TOWN OF MONUMENT - WATERLINE AND STORAGE TANK
 SITE DEVELOPMENT PLANS
 LOT 6, FOREST VIEW ESTATES FILING NO. 4

2.0 MG WATER STORAGE TANK

SITE DEVELOPMENT PLANS

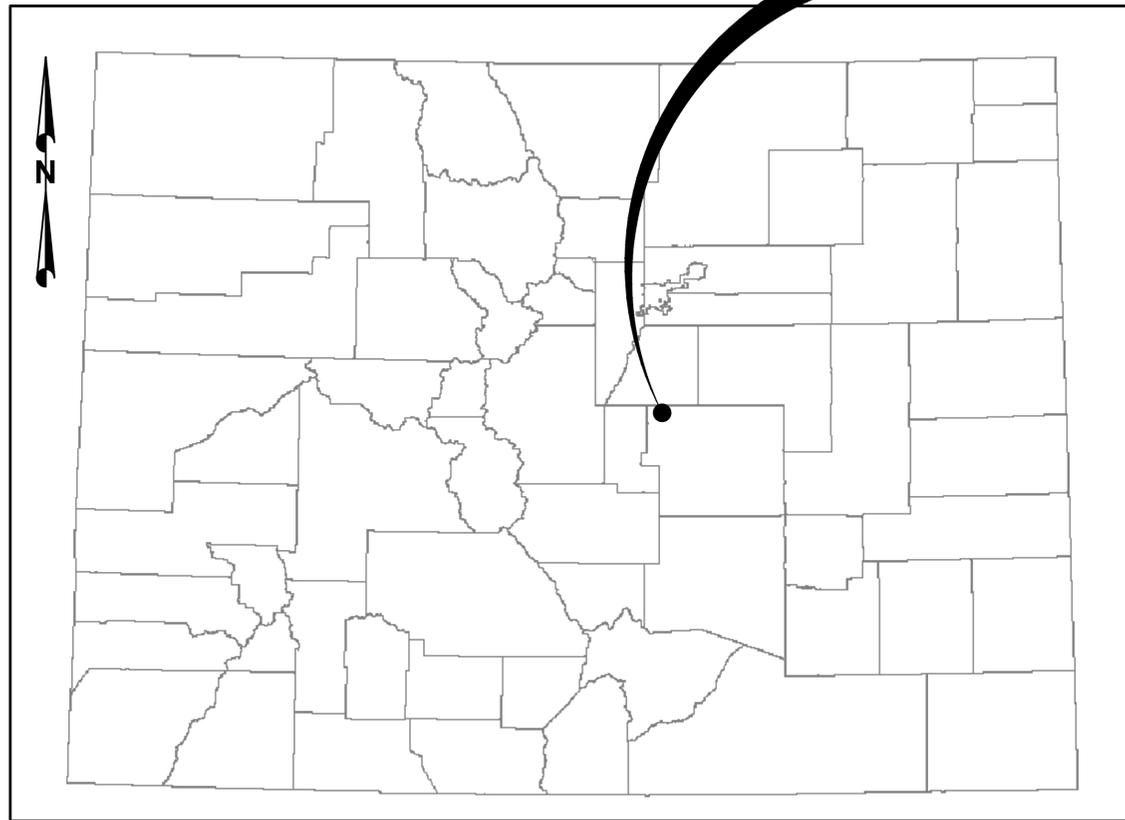
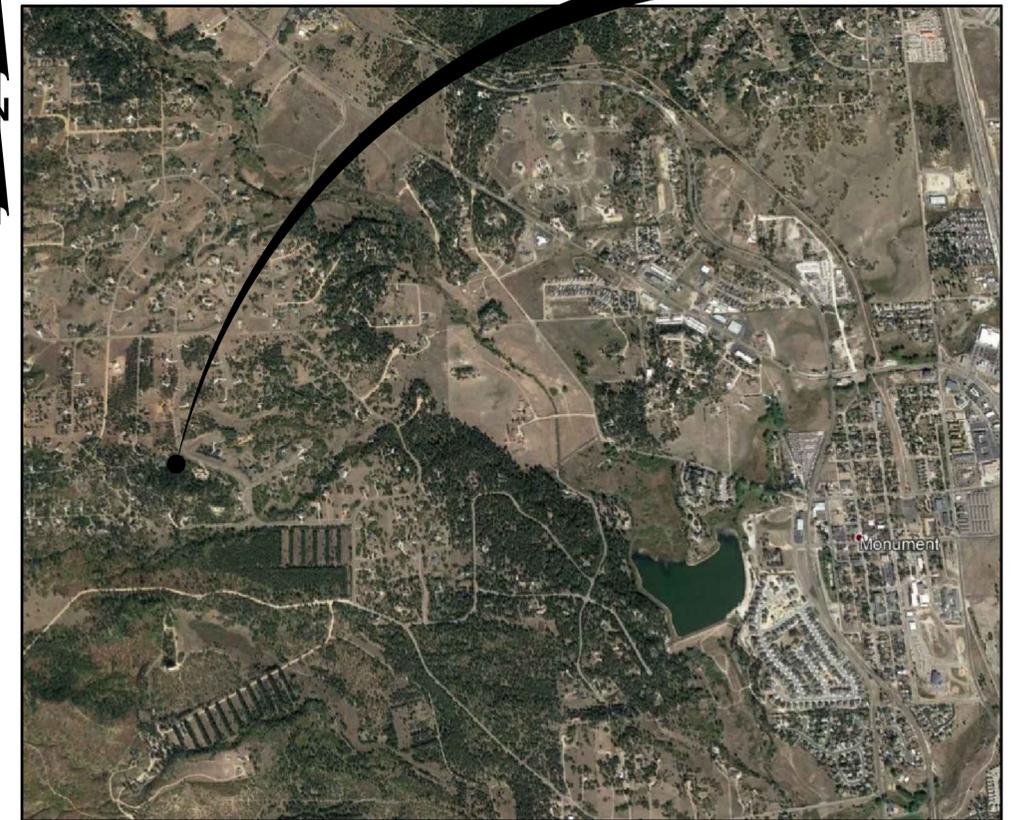
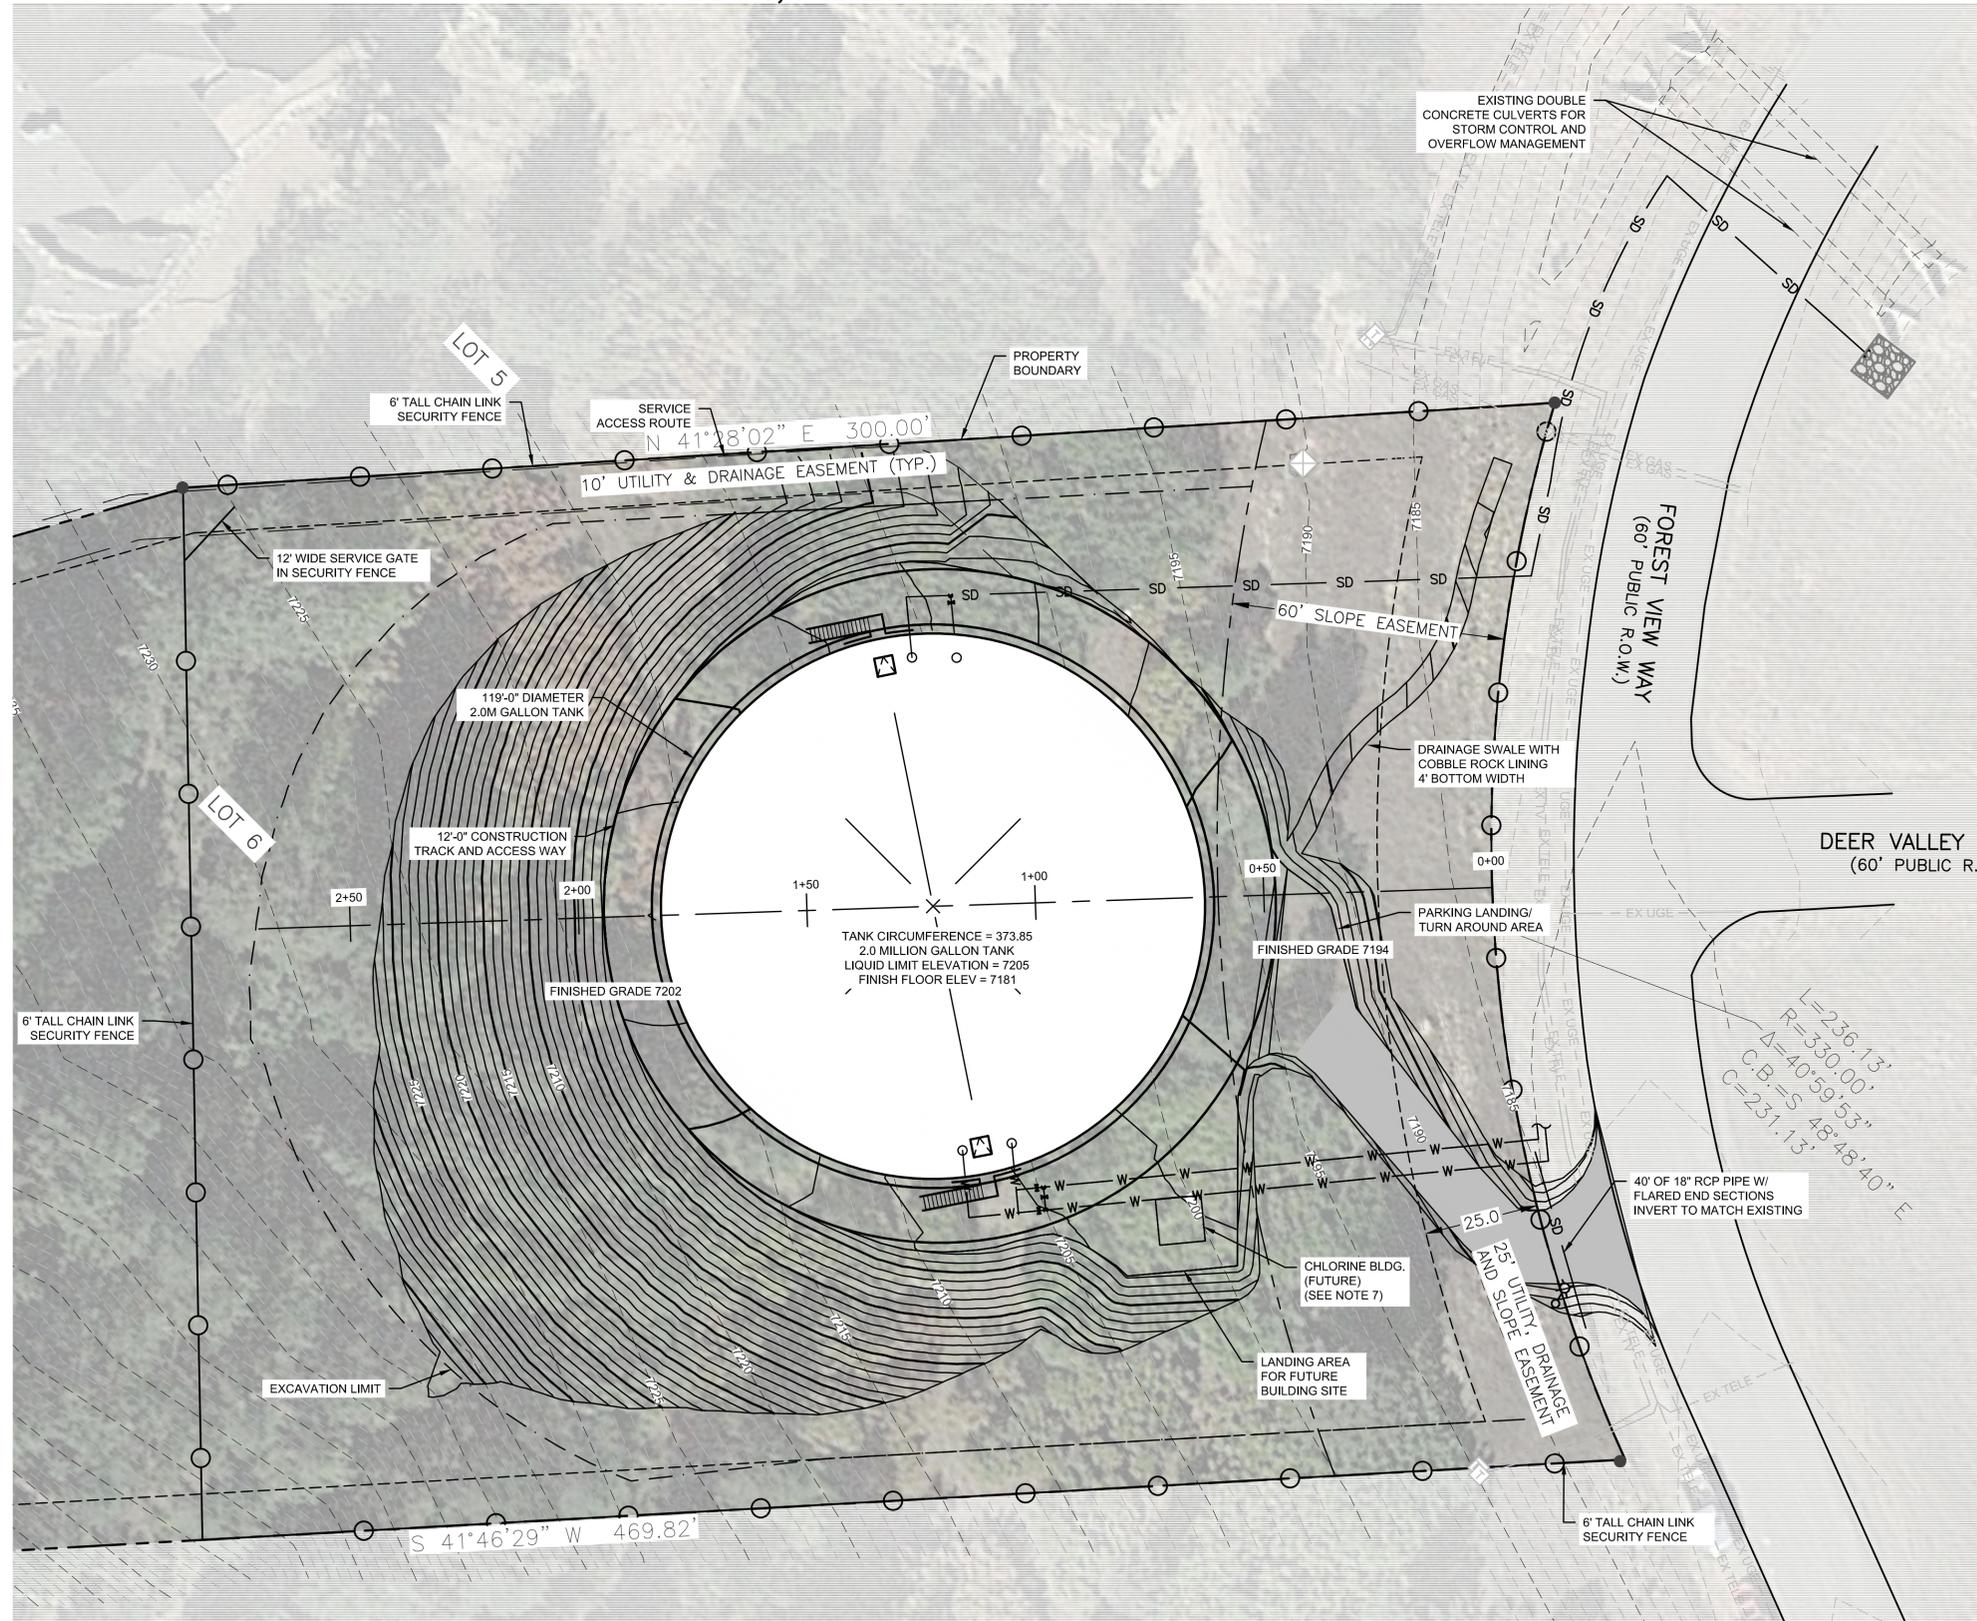
Please add the note: No construction is allowed in the ROW until approval of waterline construction drawings.
